From: Anita Gardner
Sent: 30 January 2019 15:45
To: Planning.Responses
Subject: FW: LU/328/18/PL 90/91South Terrace, Littlehampton

Subject: RE: LU/328/18/PL 90/91 South Terrace, Littlehampton

From: Anita Gardner [<mailto:Anita.Gardner@arun.gov.uk>]
Sent: 04 December 2018 11:44
To: Edmund T. Green [REDACTED]
Subject: LU/328/18/PL 90/91South Terrace, Littlehampton

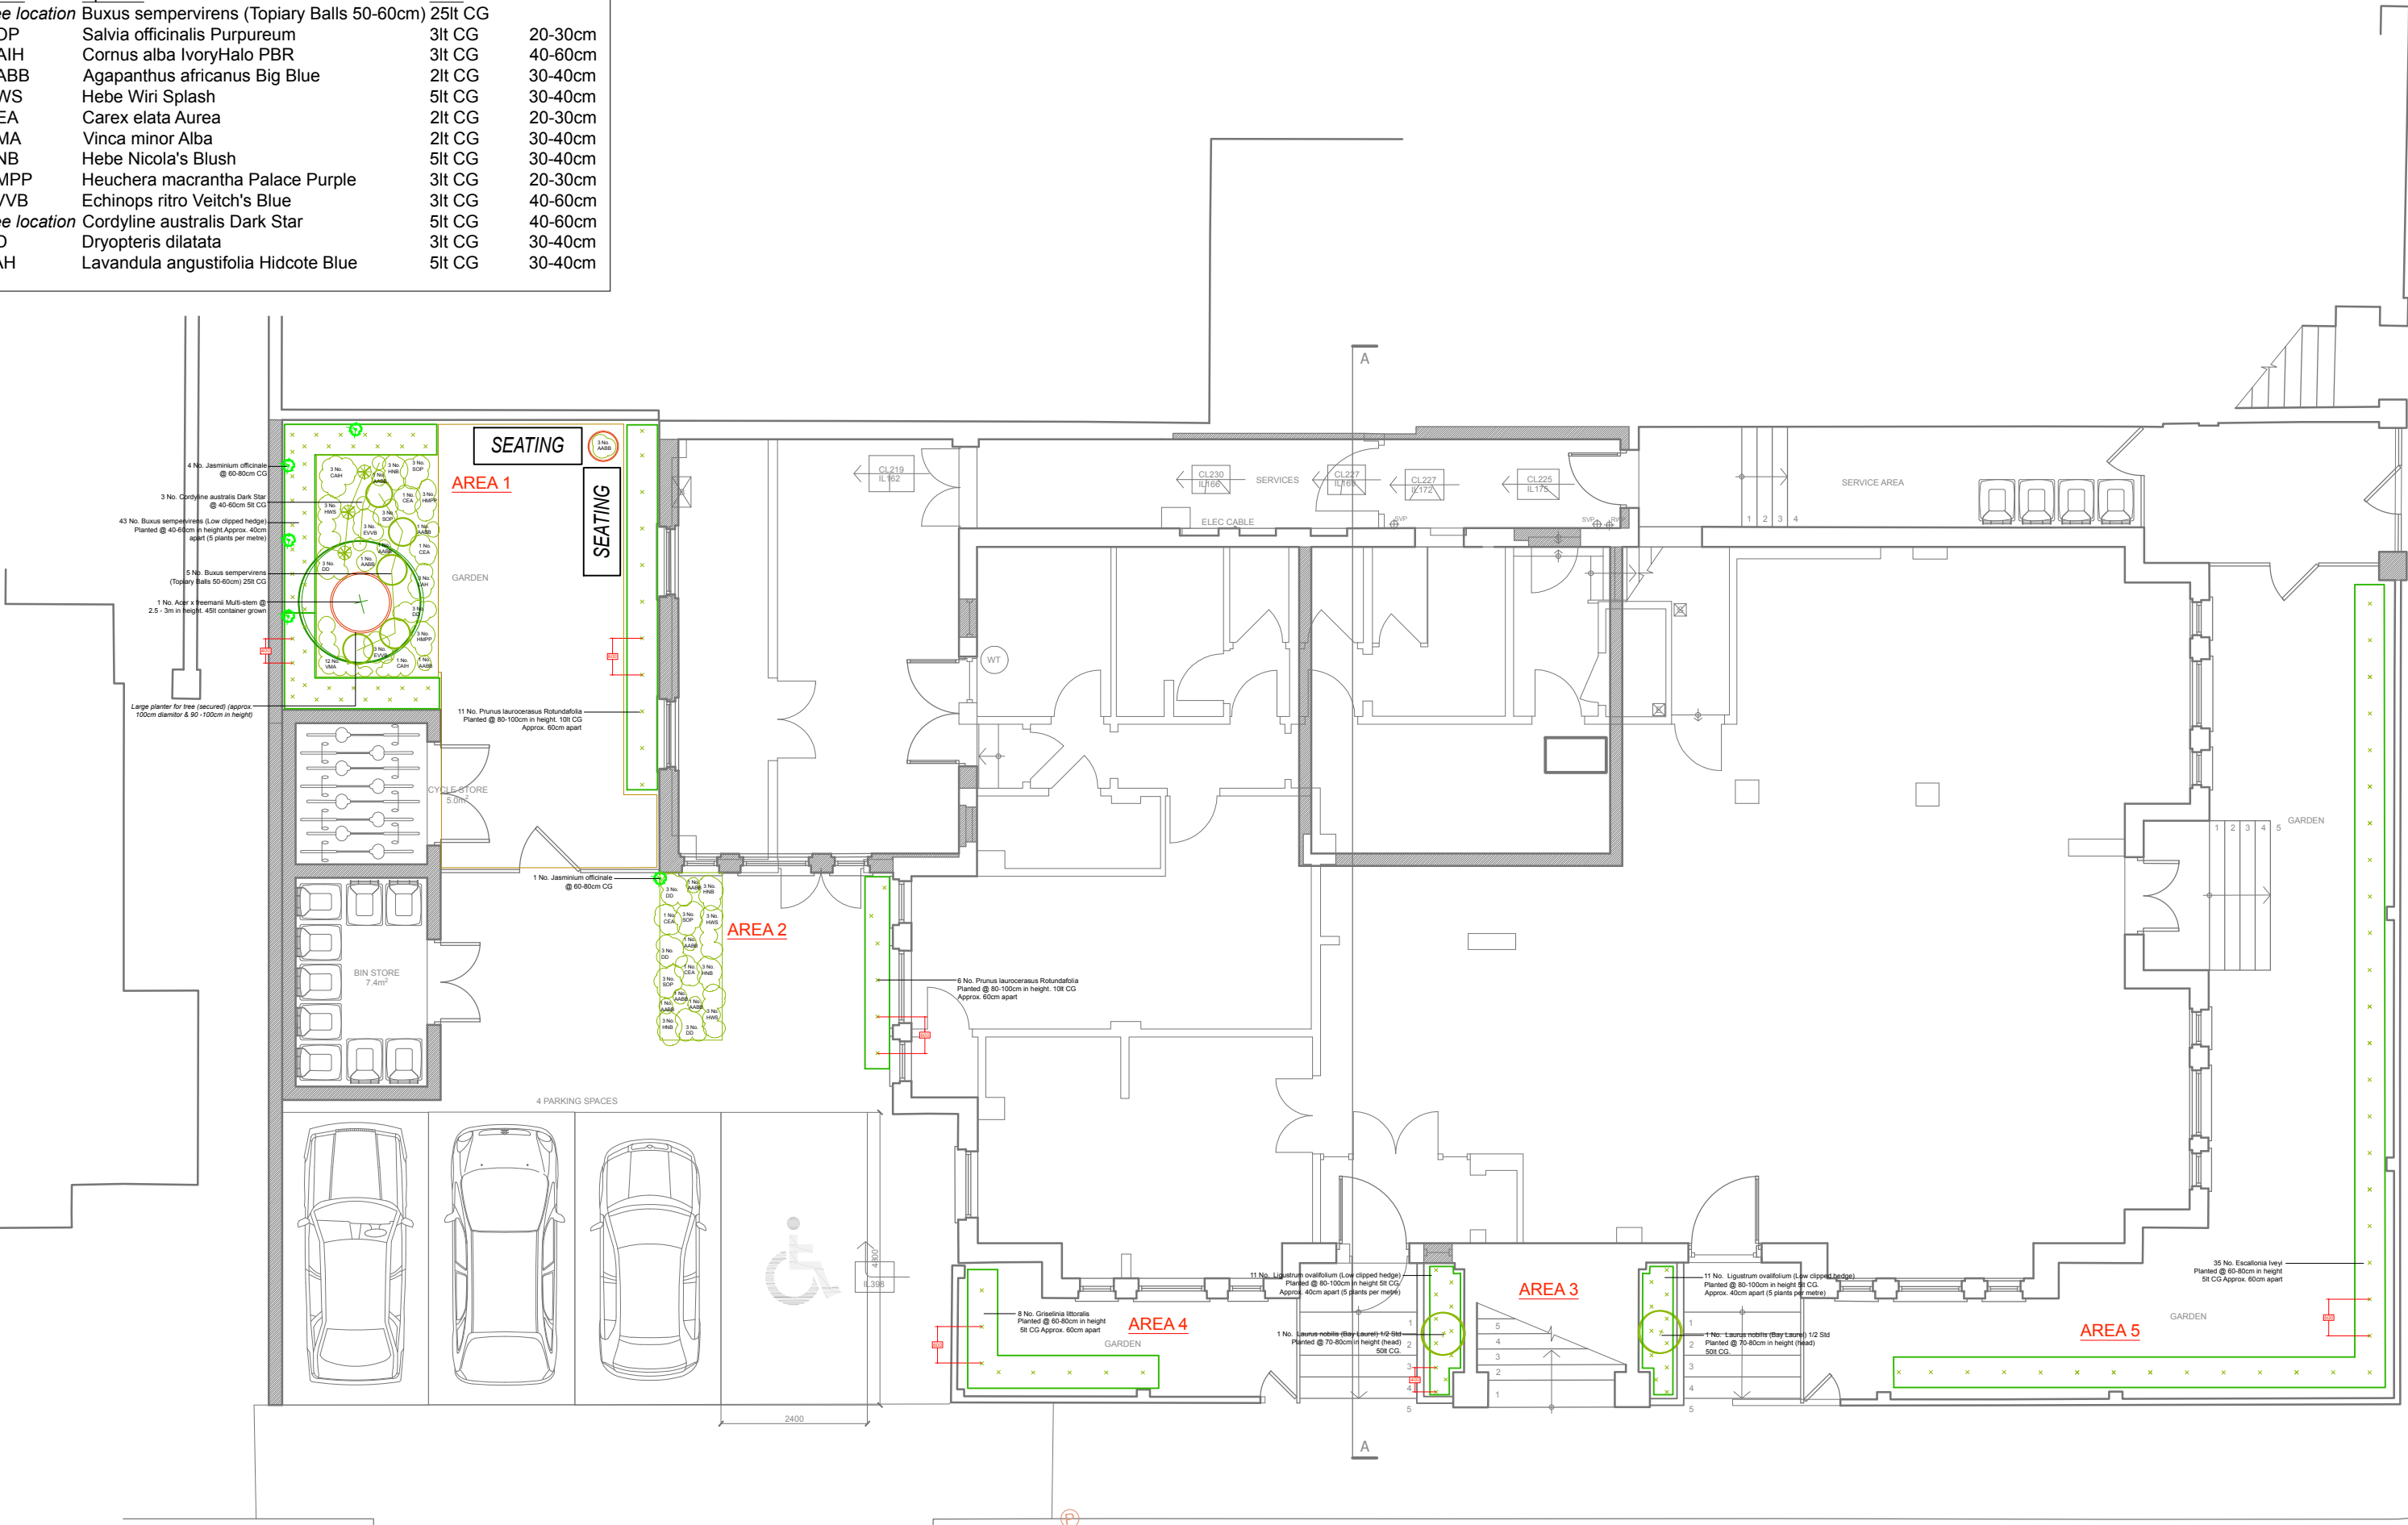
Hi Edmund,
Please can you indicate the railings on the landscaping layout plans and the street scene
Regards
Anita

I hope you are well. Please find the attached revised landscaping scheme showing the railings as requested. Please confirm receipt of the attached.
